Permit Number: 040745

This is to certify that Gurney Keith & Susan Jts/Ov  
has permission to build 10'x16' shed to be set on cinder blocks  
AT 155 Ray St 407 A003001

<b>Proposed Use:</b> 10'x 16' shed	<b>Proposed Project Description:</b> build 10x16' shed to be set on 9 cinder blocks
---------------------------------------	--

STANDARD BOUNDARY SURVEY  
 AT  
 155 RAY STREET  
 PORTLAND MAINE  
 FOR  
 KETH & SUSAN GURNEY  
 BY  
 OWEN HASKELL, INC.  
 8 BROADWAY  
 SOUTH PORTLAND, ME.  
 SCALE 1" = 20'  
 FBK 621 DATE JULY 1992  
 PROJ. # 92088P

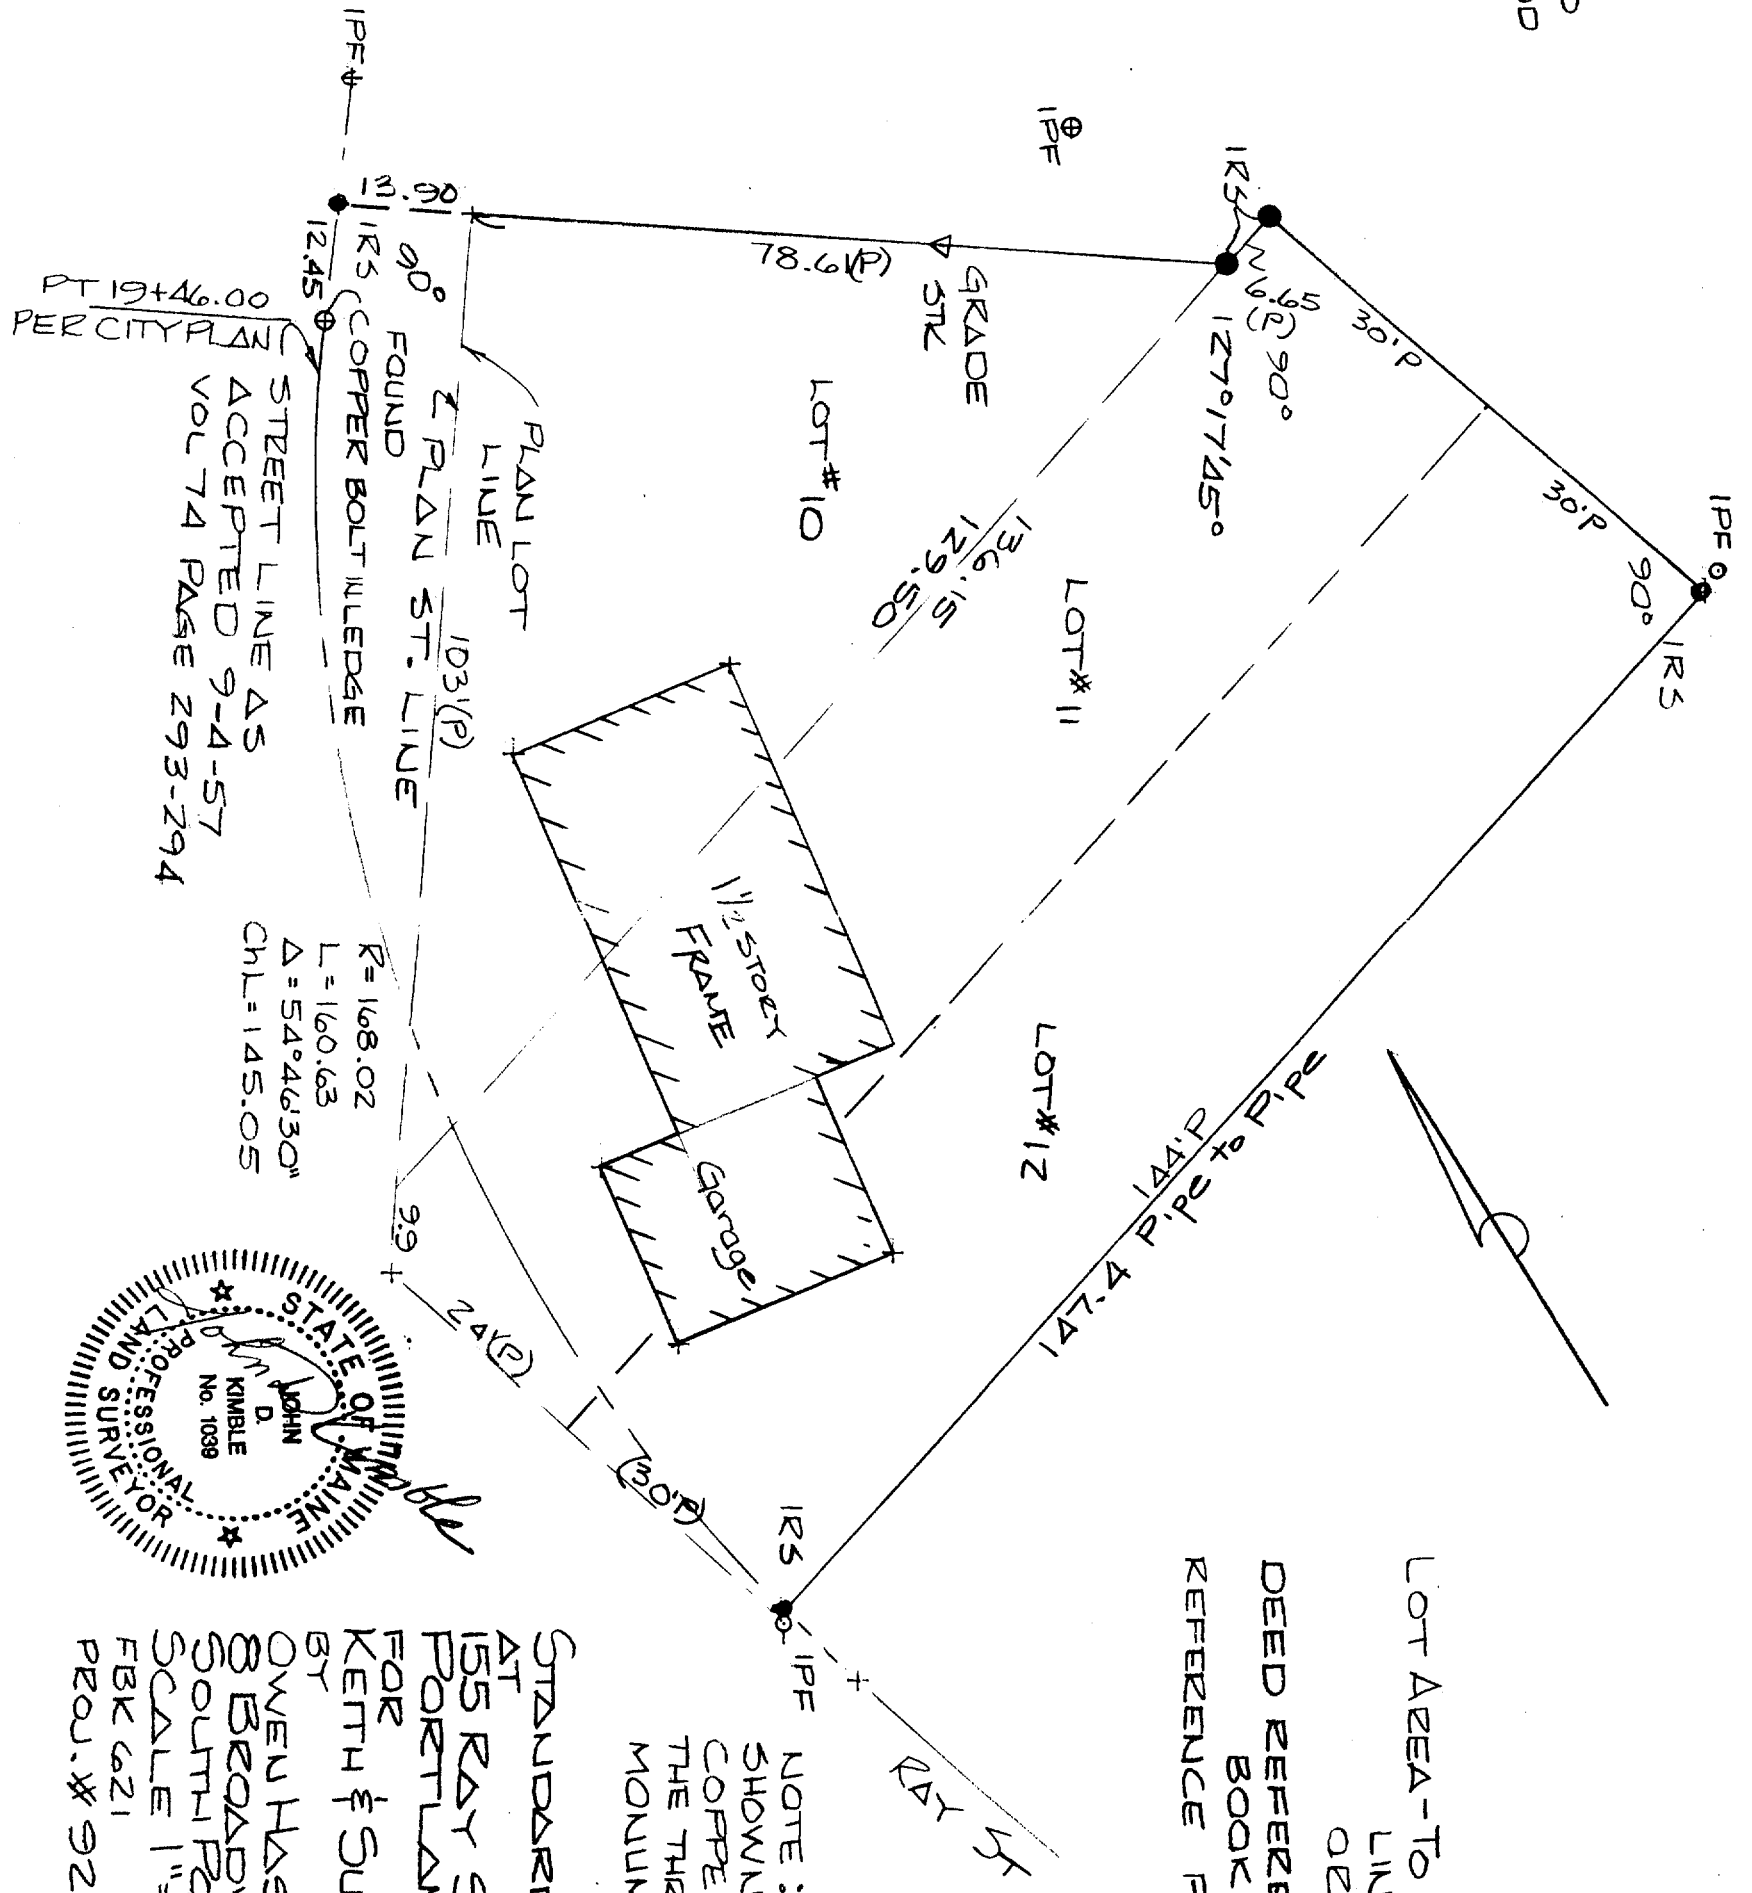
**Comments:**  
 6/11/04-tmm: Need complete plot plan - part of property is in a stream protection distric and possibly a flood zone - **left** message w/owner.  
 6/18/04-tmm: New plot plan submitted - not in flood plain or stream prot. Zone - **ok** to issue.
